## About the application

Application number: 2023/93539	
What is the application for?:	Outline application, including the considerations of access appearance, layout,
Address of the site or building:	Land adj, Ledgard Bridge Mill, Back Station Road, Mirfield, WF14 8NZ
Postcode:

Project	Proposed residential scheme at Ledgard Bridge, Mirfield
Client	Binks Executive Homes Ltd, Cawthorne, Barnsley S75 4EJ
Dwg Title	(17001)10_Elevations
Scale	1:200 @ A1
Date	Jan 22

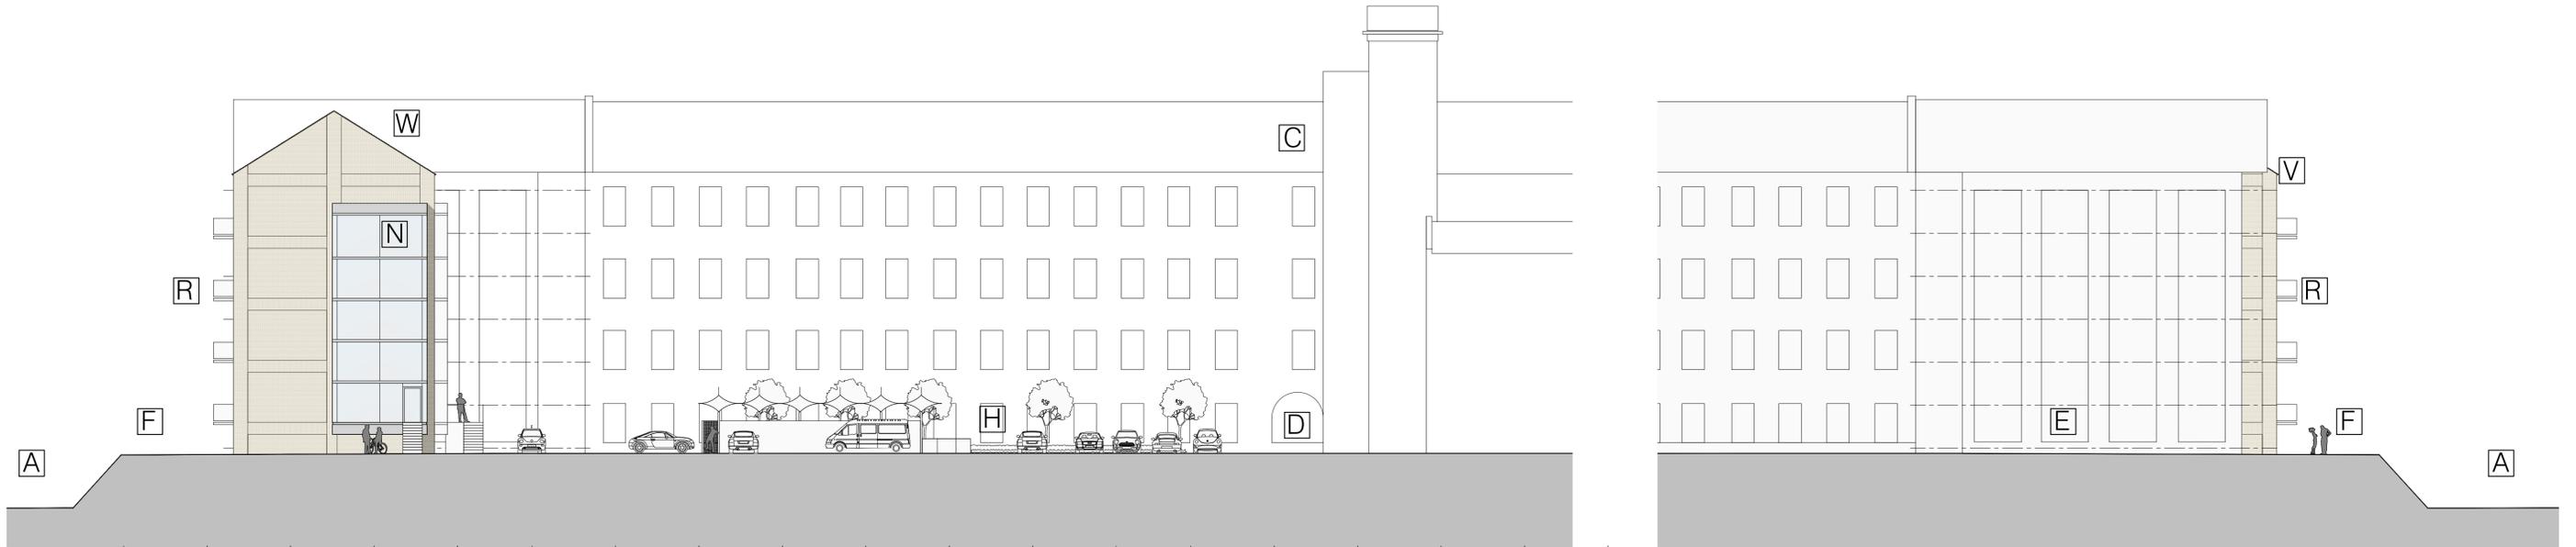
Type of comment: An objection	
Do you wish your comments to be published on the website anonymously?	Yes
<p>My main objection is to the height of the proposed building. Why does it have to be the same height as the existing mill building? As there been any consideration, to what affect this building, due to its height, would have on the wind flow around the area. The existing building, already channels the wind down back station road.</p> <p>The size of the building, must block some light from the existing houses in the area and spoil the view.</p> <p>Another concern of mine, is the amount of extra traffic that would be using back station road. Its not easy, as it is, due to the parked cars and the heavy vehicles, that use it at the moment.</p> <p>I hope the planning will be rejected, but if not, then the height of the building is reduced.</p>
